AN BORD PLEANÁLA
LDG- 073961-24
ABP- _____
14 AUG 2024
Fee: € 220 Type: pmo
Time: 10:03 By: post

I wish to appeal a decision made by Kerry Co. Council enforcement office dated 30th July 2024. I believe this decision is unjust. This pertains to a shed. I am enclosing copy of all communication to and from Kerry Co. Council Planning Department. I am also enclosing copies of photos which we took showing before and after of shed. Enclosed is a money order for 220 Euro.

**Ref: 9761
Date: 14/06/2024**

9761 - Poulawaddra, Ballyseed y, Tralee

Before

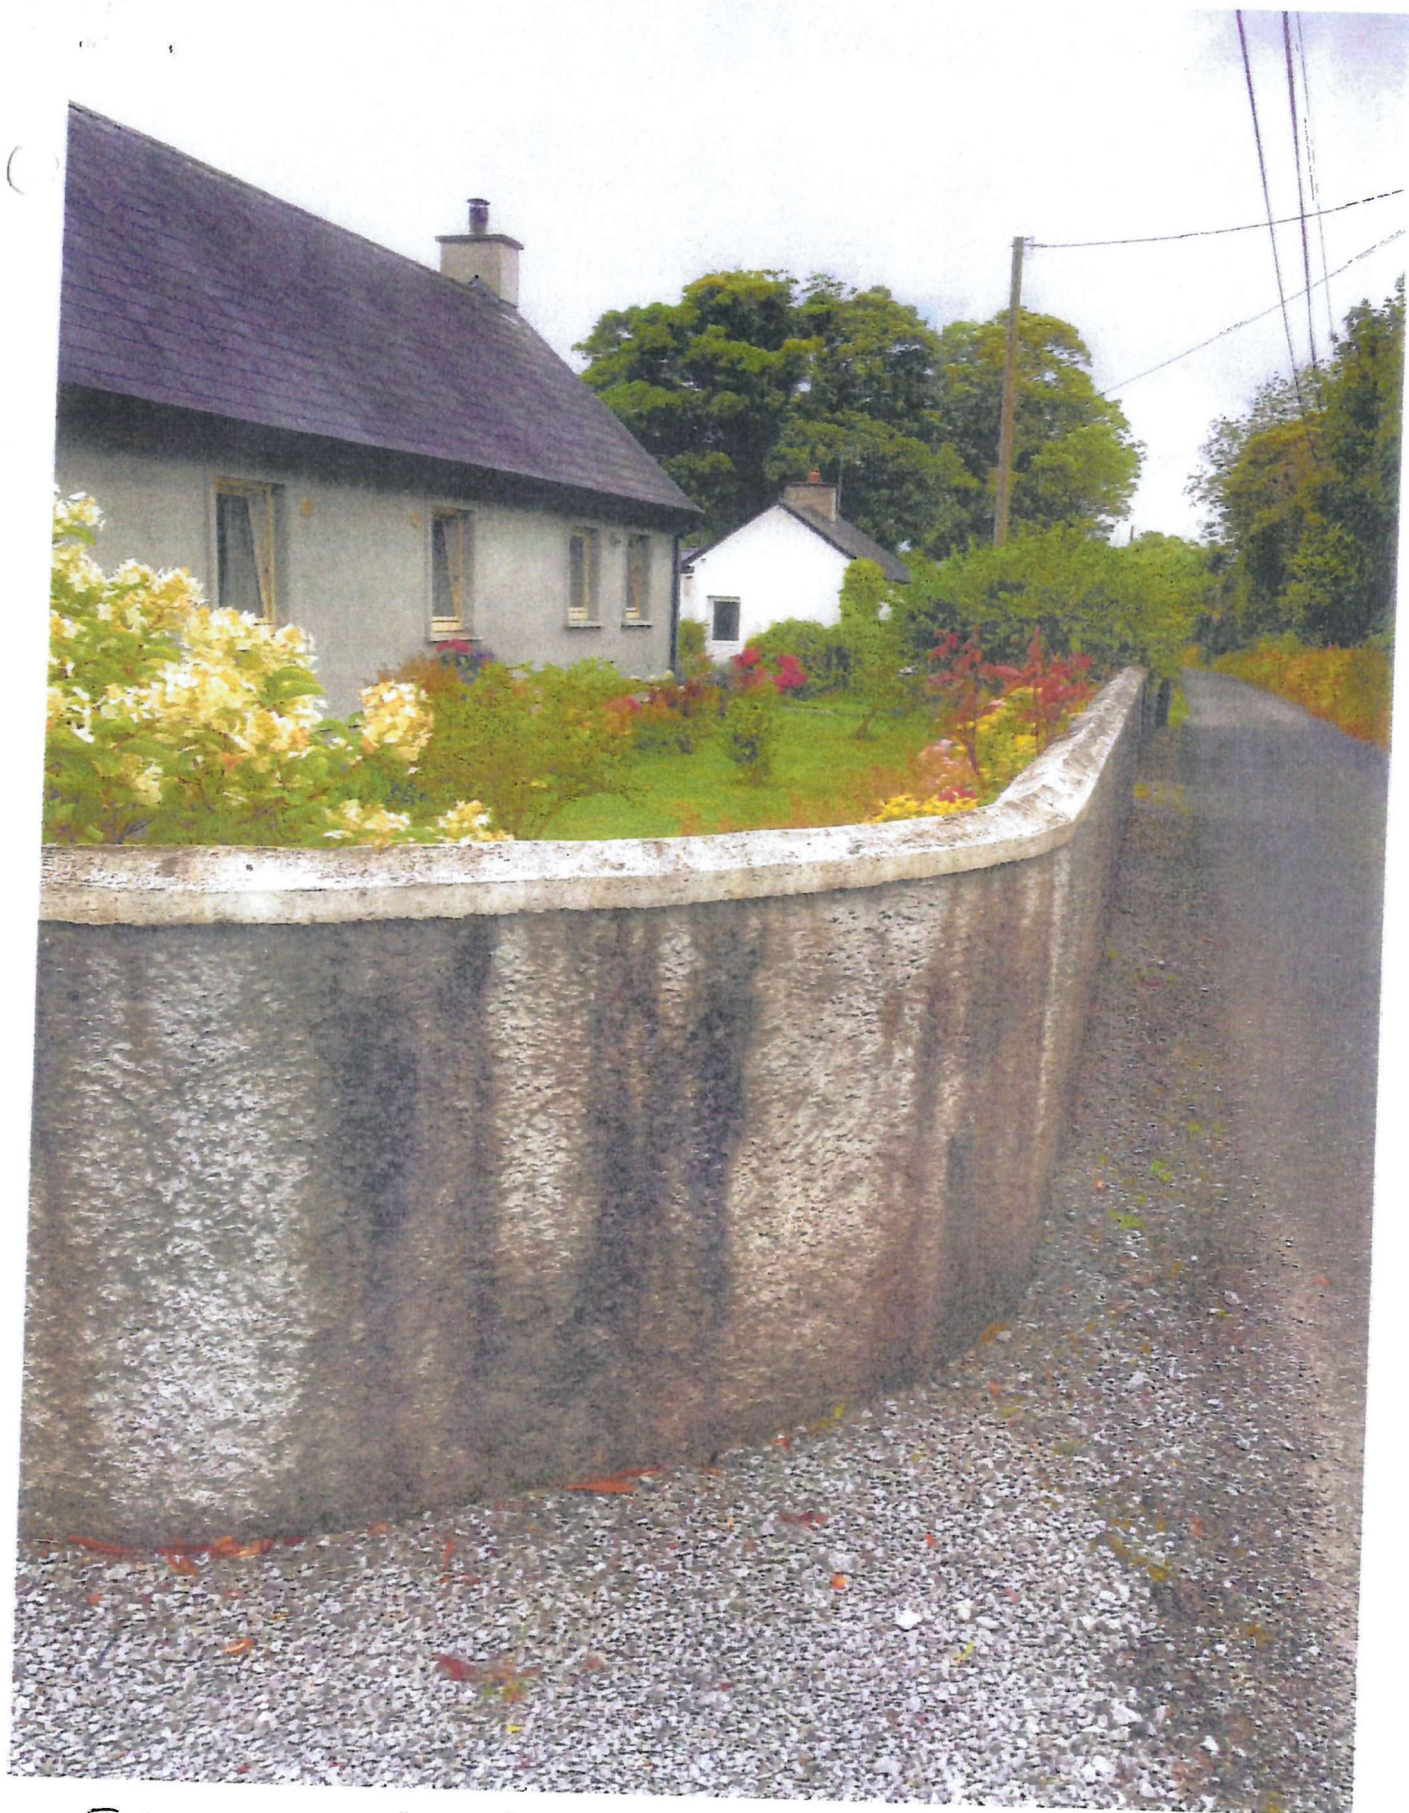
These photos show the before and after

Due to damage caused I believe it was a Health and Safety issue which we addressed at considerable cost to our family. (Photographic evidence)

To be considered for exemption under Section 4(1)(h) of the Planning and Development Act 2000 as amended, renovation of the original shed without changing the external appearance of the shed would be the scope of work. However, that is not the case in this situation as the original shed has been demolished and a new larger shed constructed in a similar location.

The works which have taken place is demolition of the original shed and construction of a new shed, which is considered development under the Planning and Development Act which would need permission.

9761 – Poulawaddra, Ballyseedy

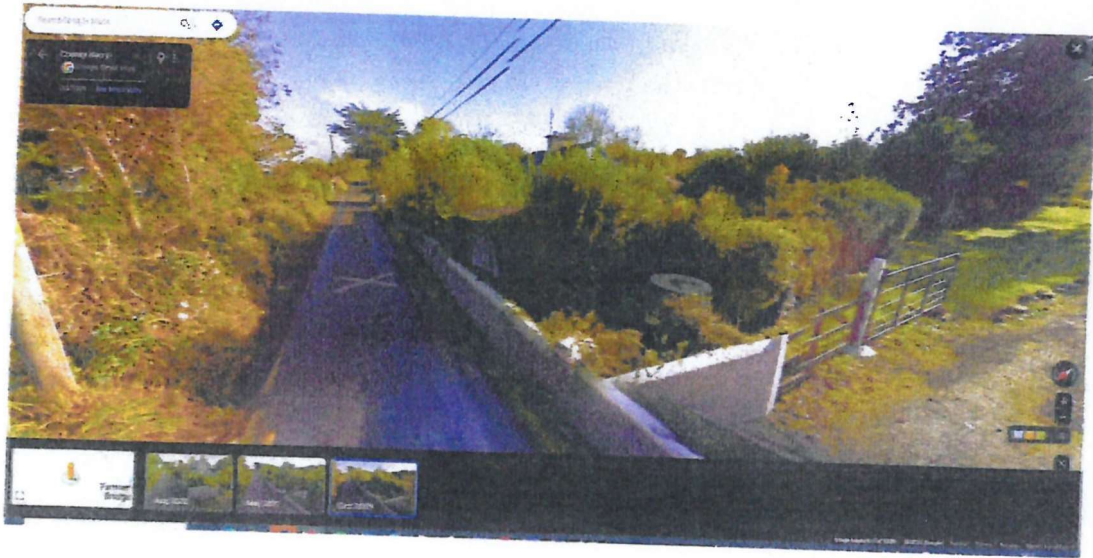
In your correspondence of 15/07/2024, you describe the floor area of the newer shed as 8m², but the shed on PRN 13/554 is 4.4m², therefore the size of the shed has been nearly doubled. In your correspondence you also note the height of the shed as 2m 23cm, but the original shed is lower as can be seen on Google Maps Streetview image captures of May 2011 and October 2009.

Title: **SITE LAYOUT PLAN.**

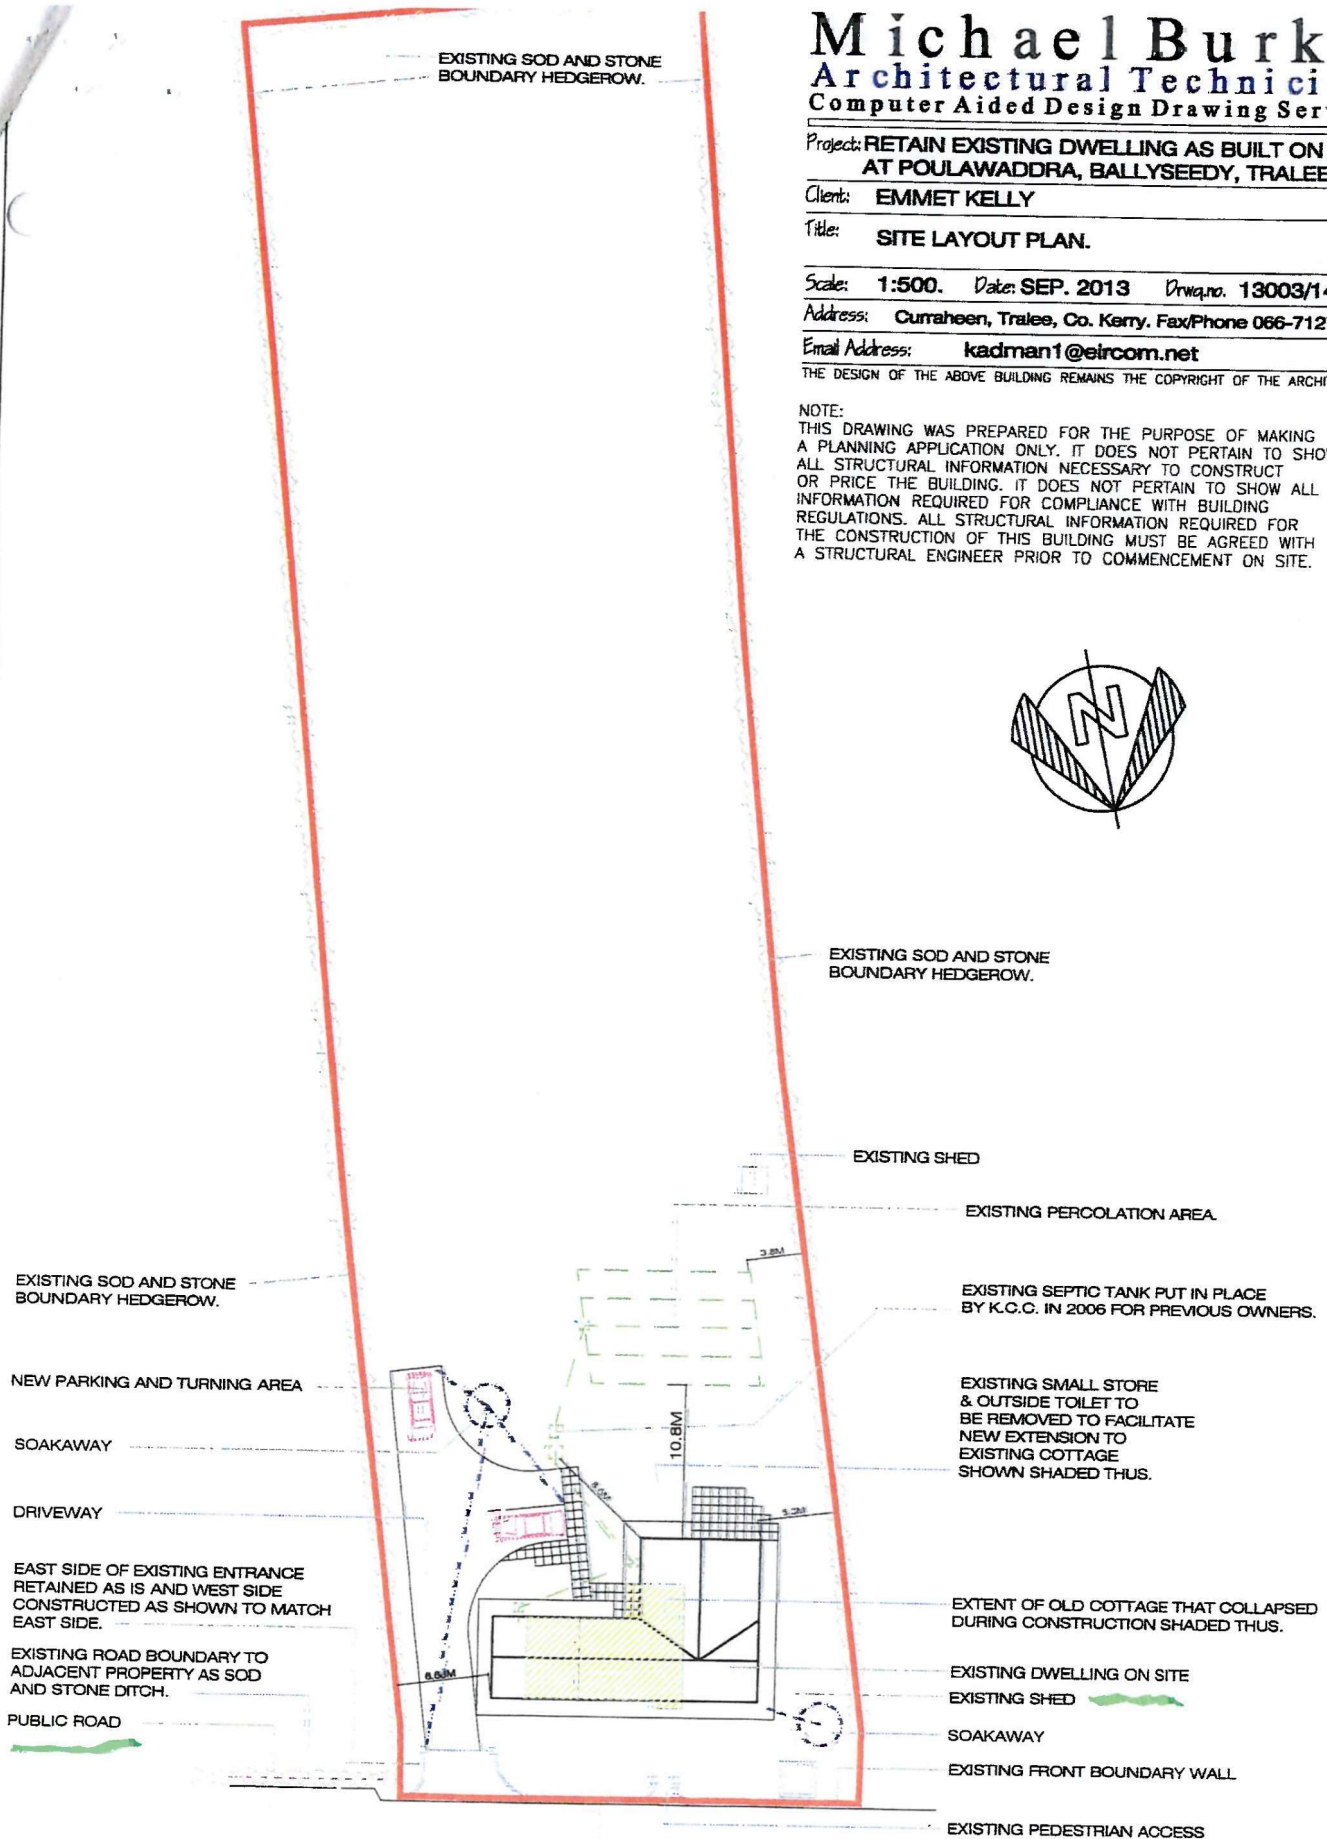
As we have previously acknowledged, we do not dispute that there was a shed on the site previously, but the structure now constructed is a new larger shed. We also note the structure you reference as shown on the planning application drawings from 2013 (PRN 13/554).

1:100 SEP. 2013 13003/11

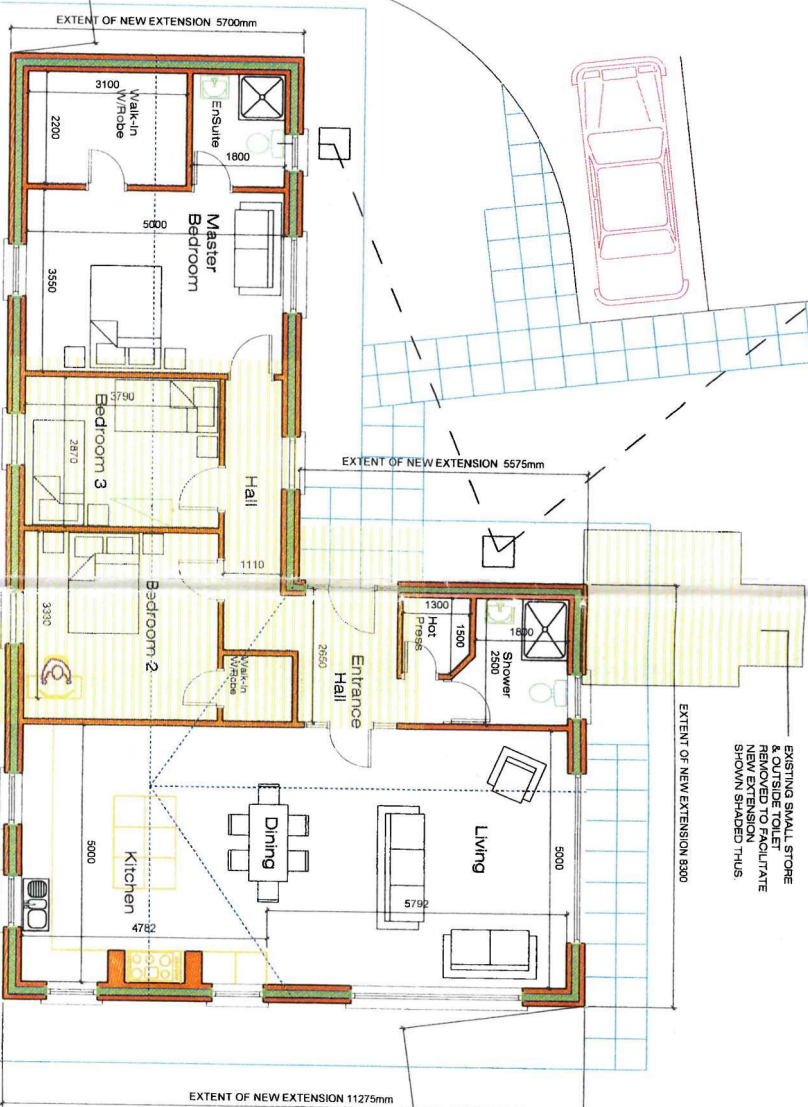
Location Where it has been for decades and as seen on Planning Application drawings 3003/11 which were submitted in 2013. I believe you have said documentation on file .See also K.C.C. maps of this area.
